CITY OF ALBUQUERQUE

Re: Dripline Development
1320 2nd St. NW
30-Day Temporary Certificate of Occupancy
Transportation Development Final Inspection
Engineer's Stamp dated 10-23-23 (J14-D046)
Certification dated 08-29-24

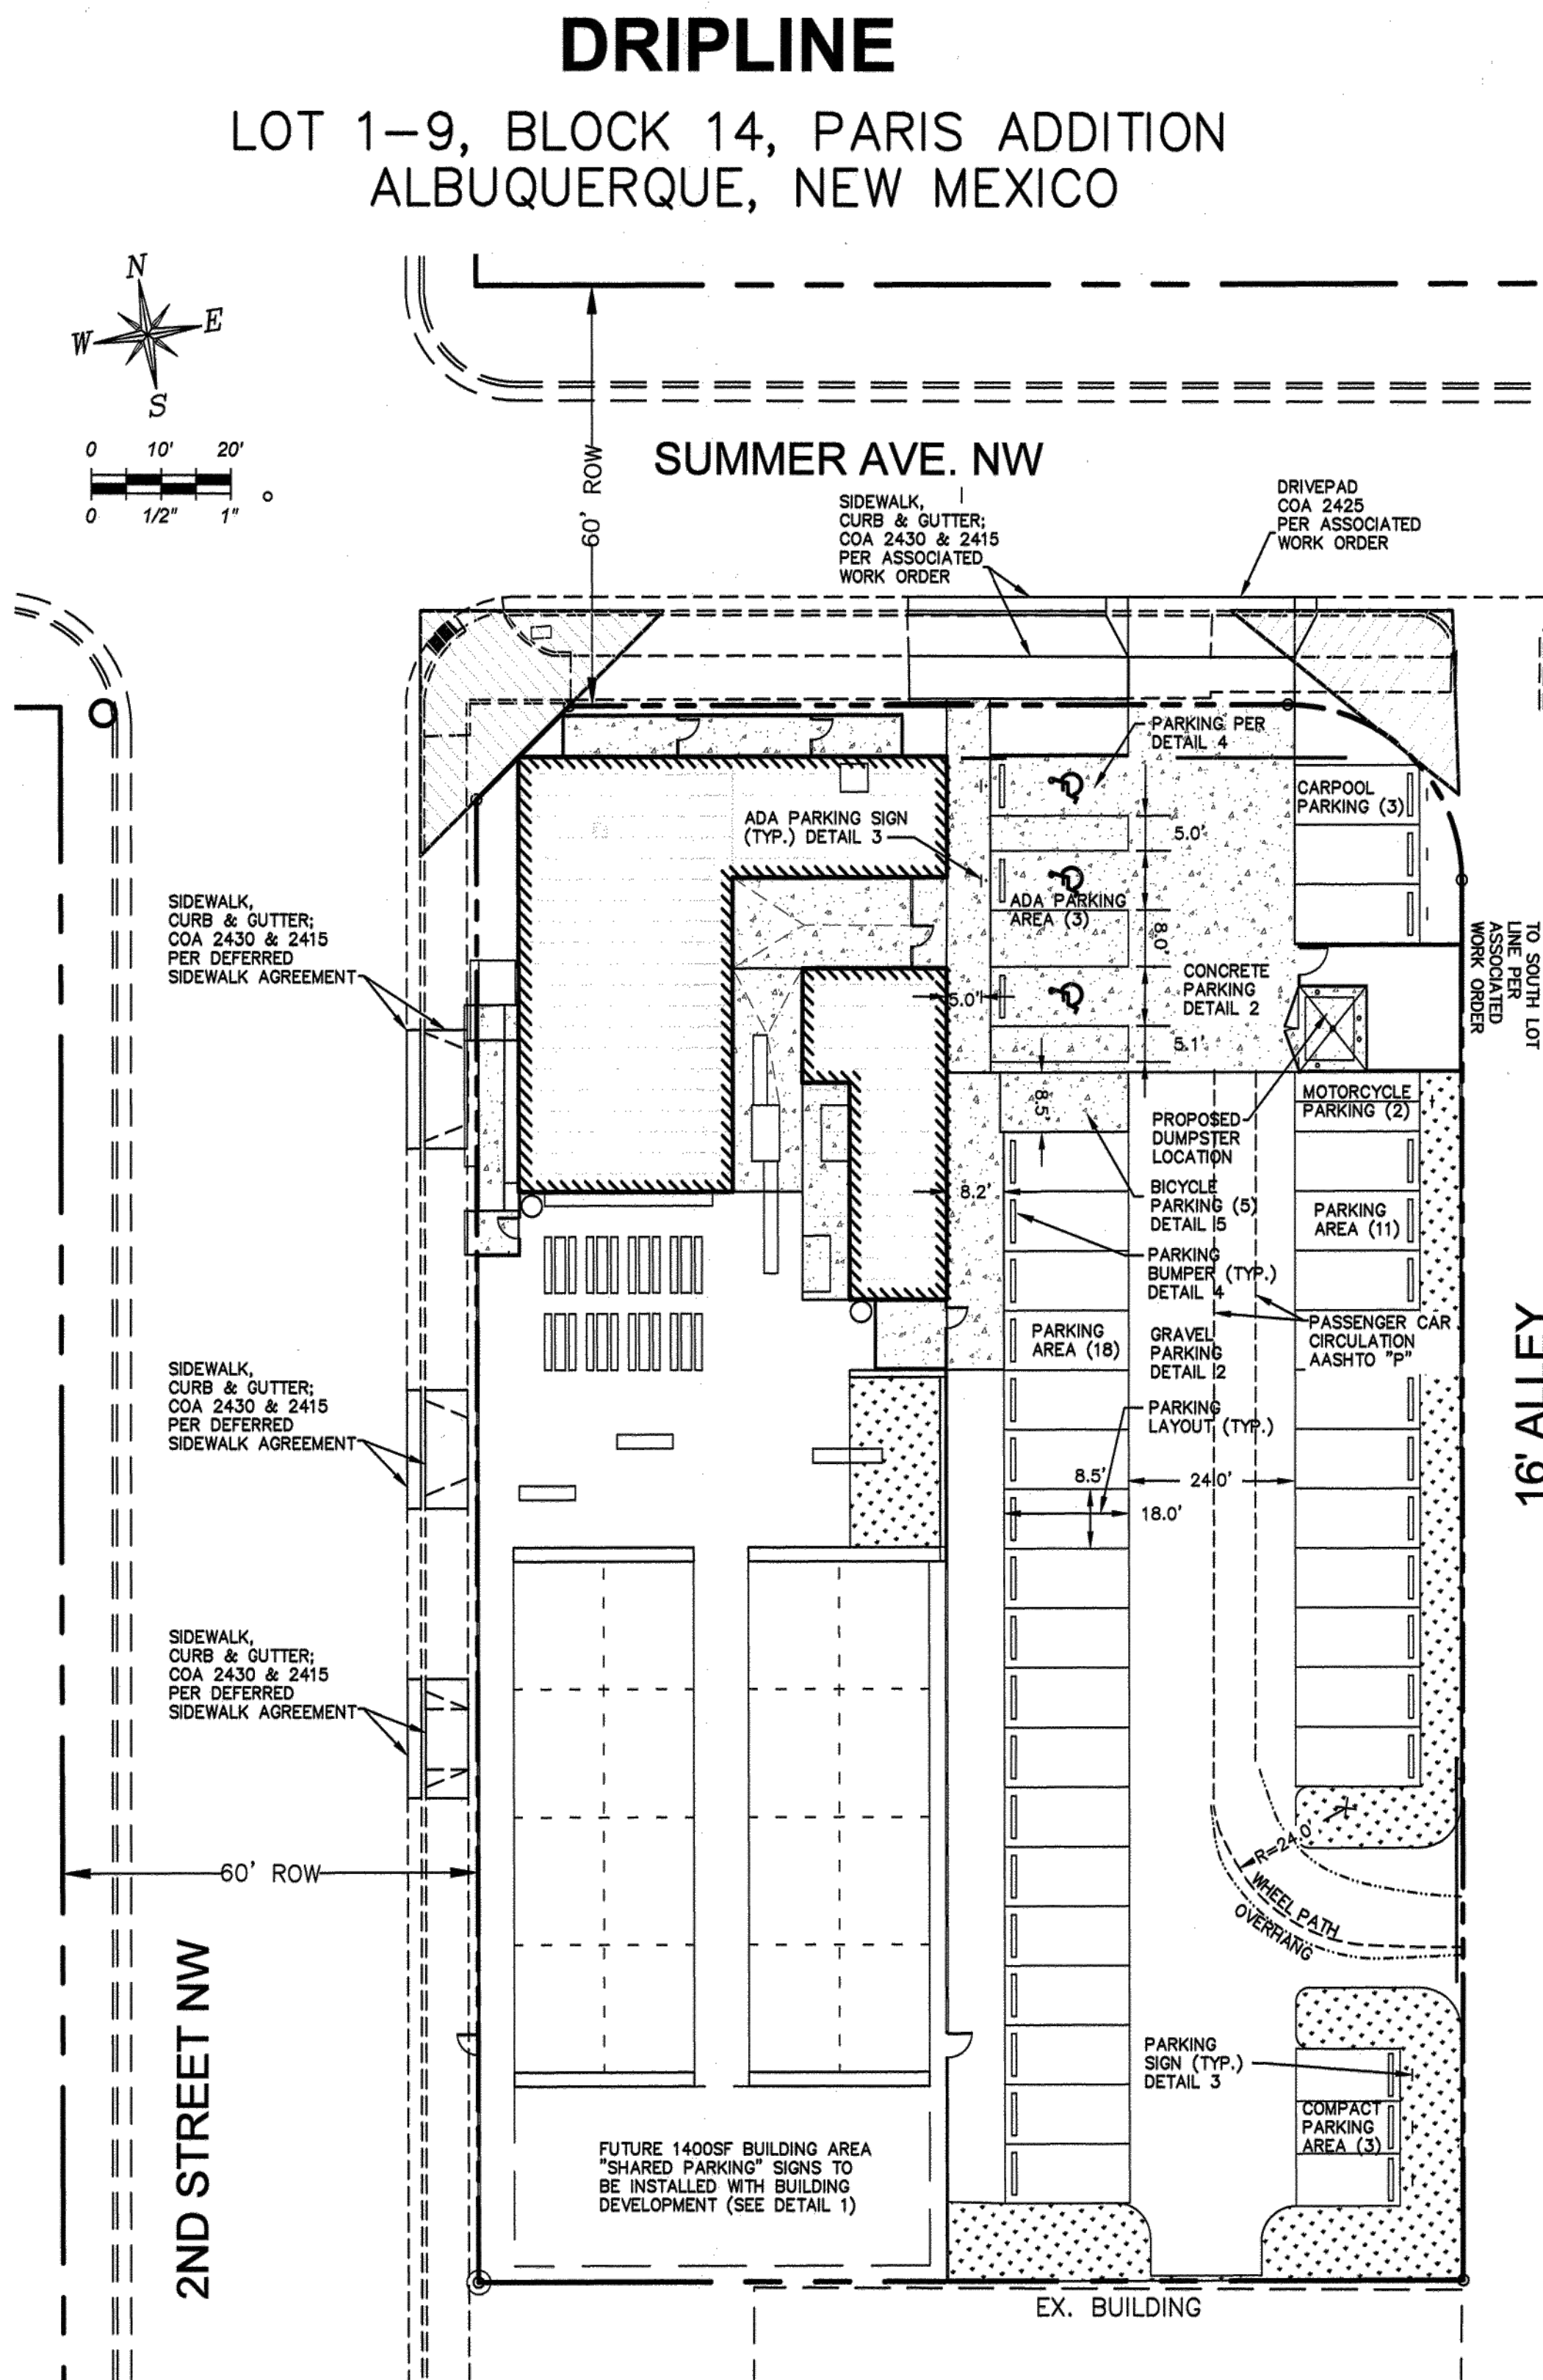
- A Truncated Domes must be installed at the corner ramp of 2ND St. and Summer Ave.
- The ADA accessible parking sign must have the required language per 66-7-352.4C NMSA 1978 **"Violators Are Subject to a Fine and/or Towing."** Please call out detail and location of signs.
